DRB Project# 1002829 Subdivision Name Vista Montecito

APPLICATION NO. 03DRB-01221	PROJECT NO. 100 2829
PROJECT NAME Vista Montecito	
EPC APPLICATION NO.	
APPLICANT / AGENT Tony Harris	PHONE NO. 889-8056
ZONE ATLAS PAGE C-13	
legitness w/ ERM 7/21	
<b>IR ONE STOP COMMENT FORM LOG</b>

DESCRIPTION OF REQUEST: combine common area with 2 existing lots

PLAT OF  
**LOT 1A-P1, BLOCK 1**  
**LOT 3A-P1, BLOCK 6**  
 AND  
**TRACTS A-1-A & C-1-A**  
**VISTA MONTECITO SUBDIVISION**

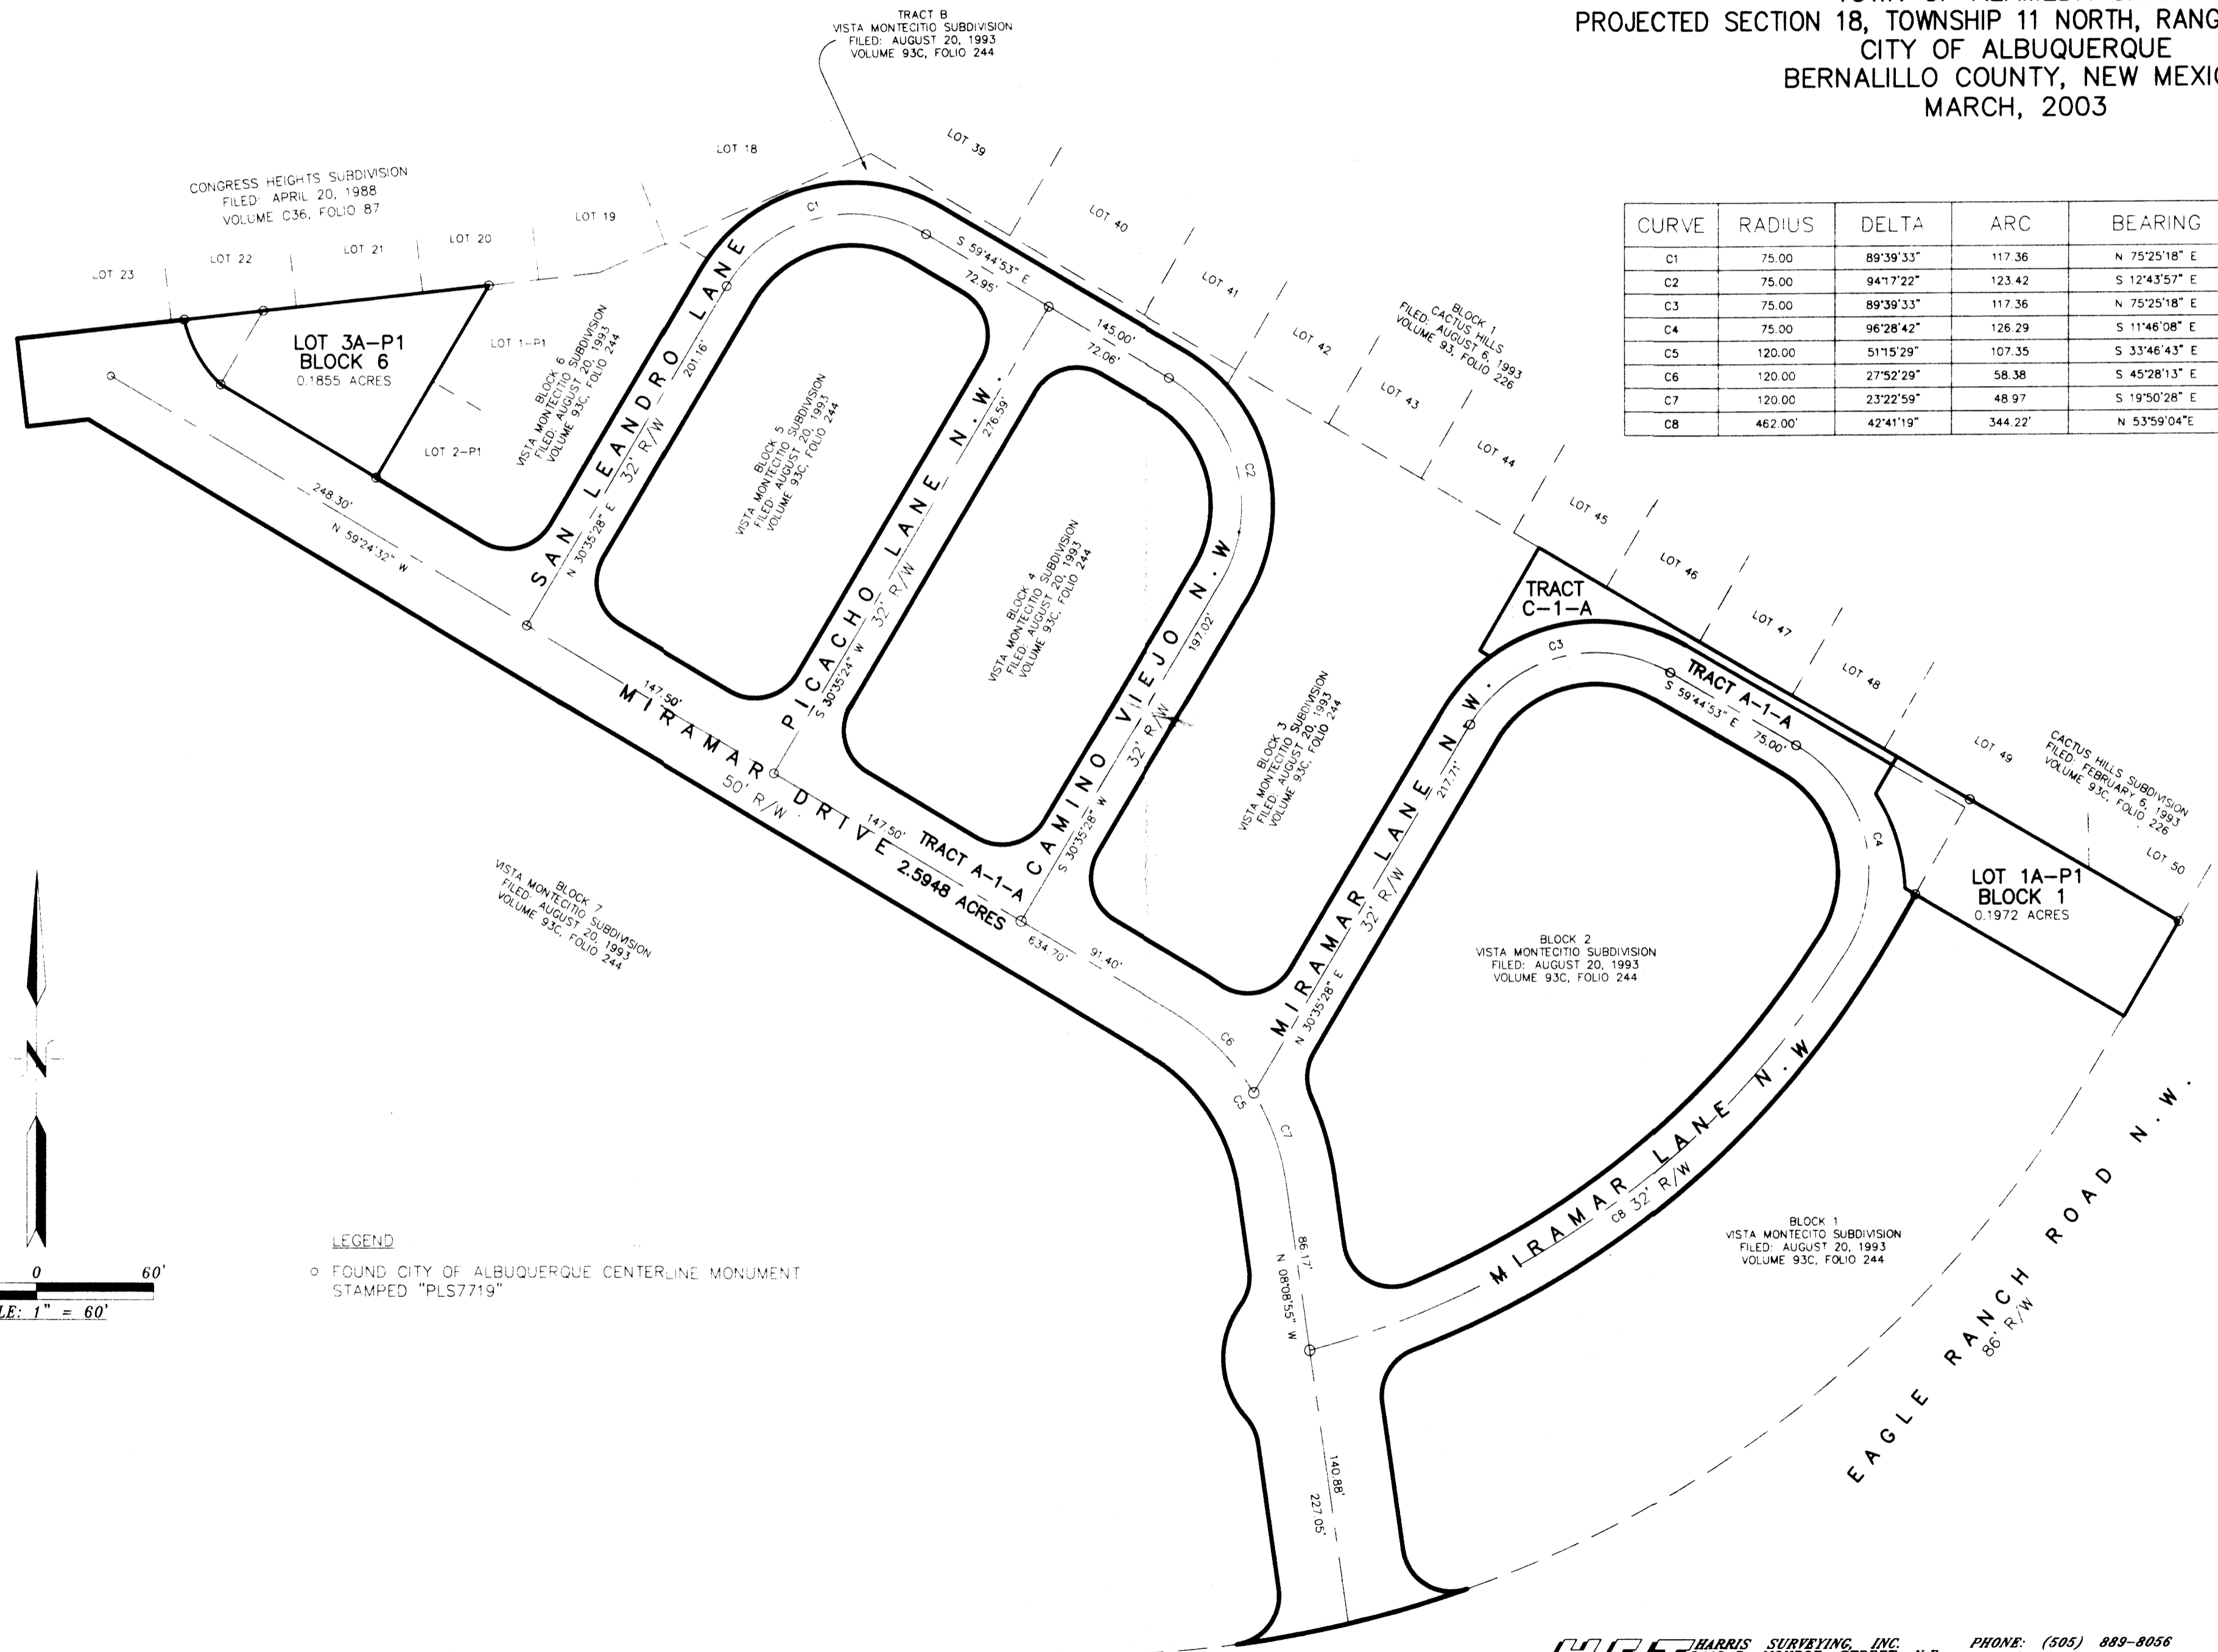
TRANSPORTATION DEV (505) 924-3990		
PLANS DISAPPROVED <i>RD</i>	DATE 7-24-03	DATE
PLANS APPROVED <i>RD</i>	DATE 8-20-03	DATE
COMMENTS:		
Entire Common AREA appears to need to be replatted.

HYDROLOGY DEV (505) 924-3986		
PLANS DISAPPROVED <i>BLB</i>	DATE 7/29/03	DATE
PLANS APPROVED <i>BLB</i>	DATE 8/20/03	DATE
COMMENTS:		
Provide copy of original plat and describe remainder of common area
